Our Case Number: ABP-318573-23

Re: A proposed Road Development comprising of the N2 Slane By-Pass and Public Realm Enhancement Scheme
Within the Townlands of Slane, County Meath

Observations on

N2 Slane Bypass and Public Realm Enhancement Scheme Project Website

Figure 4.2: Outline of the Proposed N2 Slane Bypass and Public Realm Enhancement Scheme

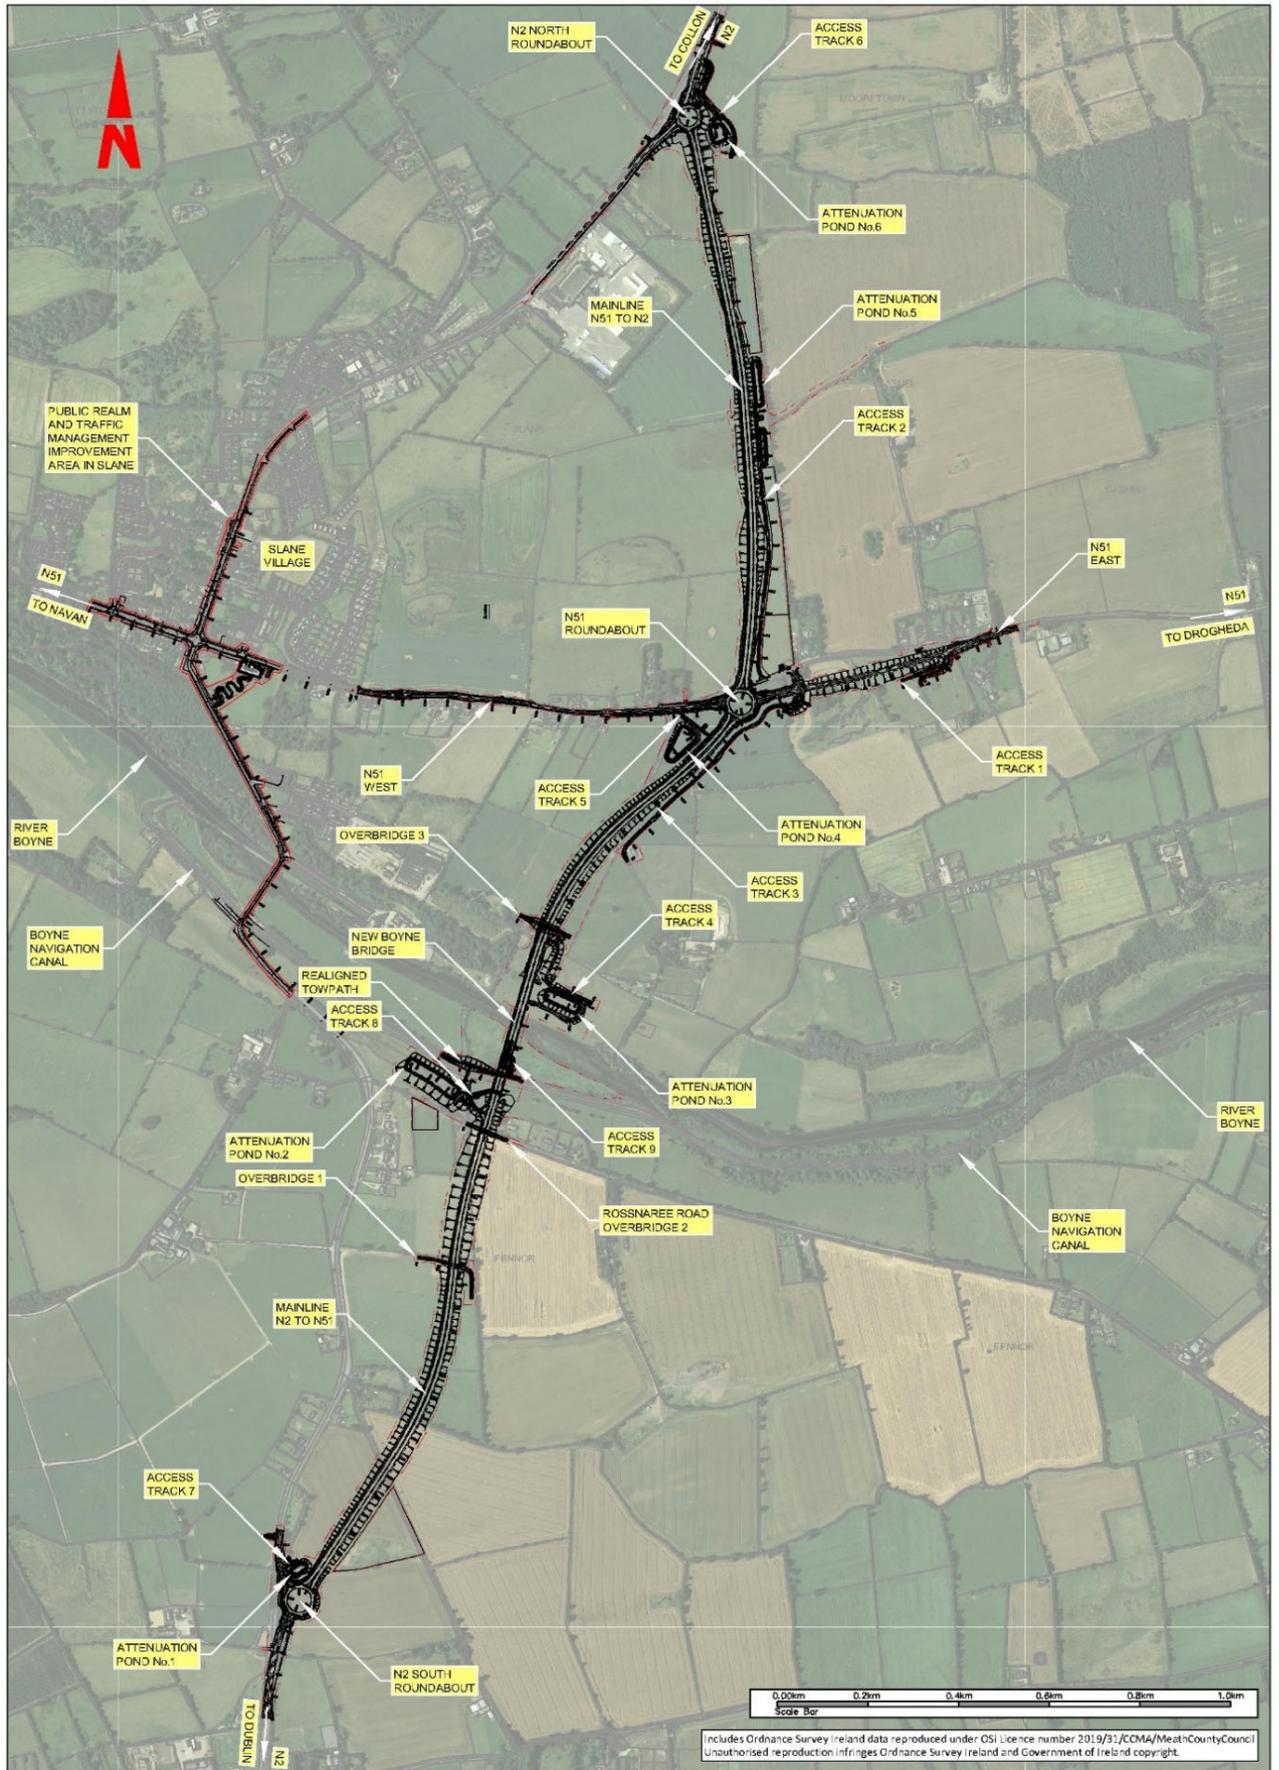
- Why does the scheme start just south of McGruder's Cross instead of at McGruder's Cross? McGruder's is the main access point to Newgrange from the N2. There is currently a sharp bend just south of the cross. Placing the proposed roundabout at McGruder's Cross would significantly improve traffic safety by providing a safe interchange to the world heritage site, eliminating two junctions in close proximity to each other and removing the bend.

Figure 4.18: Proposed Extent of Slane Public Realm Enhancement

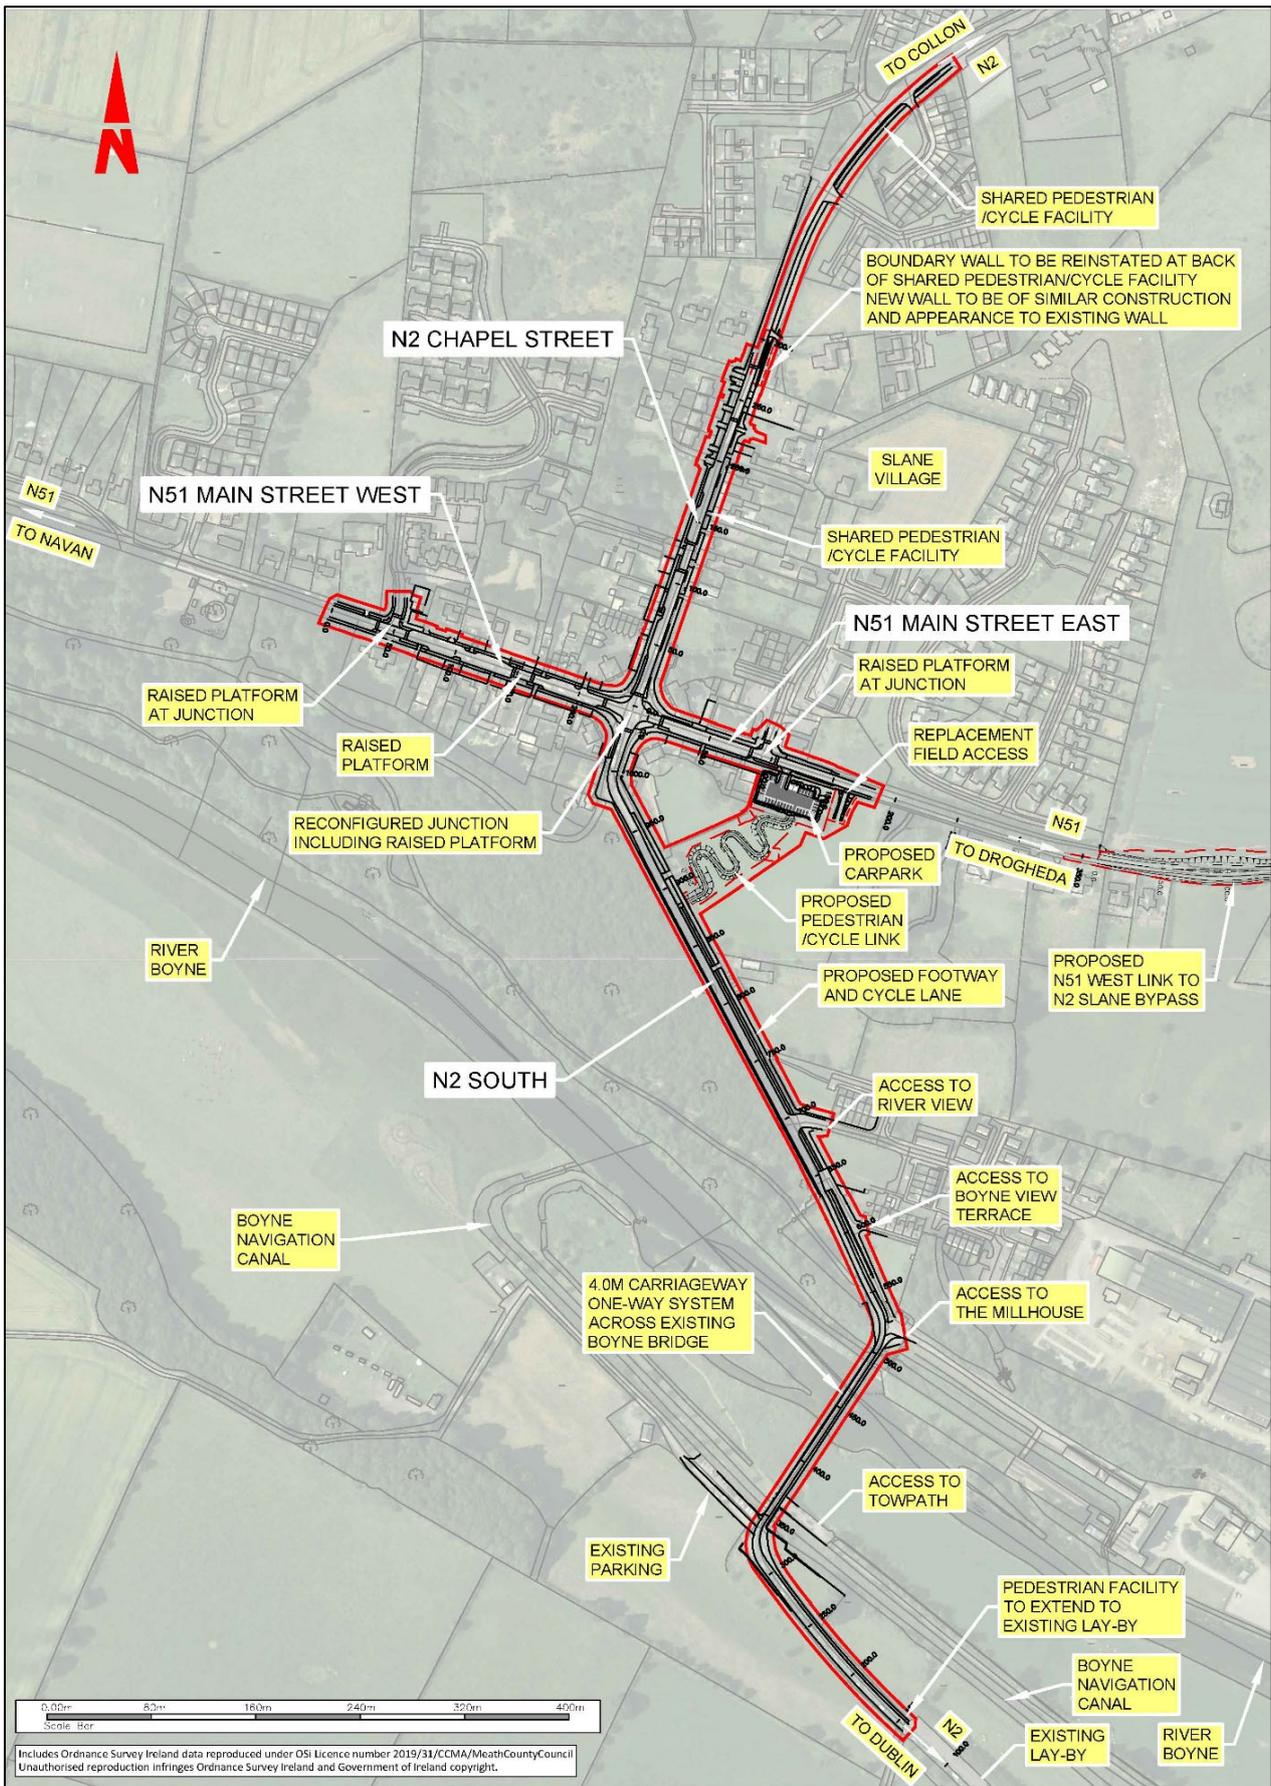
- Slane Village is a planned eighteenth century Estate Village and is designated as an architectural conservation area. The design of the enhancement scheme, and in particular the pallet of proposed materials chosen, is inappropriate for this setting eg limestone paving and cobbles would be more appropriate than white granite and red tarmac. No provision has been made for bus shelters and some of the proposed planting will actually obscure the view of some of the historic buildings.
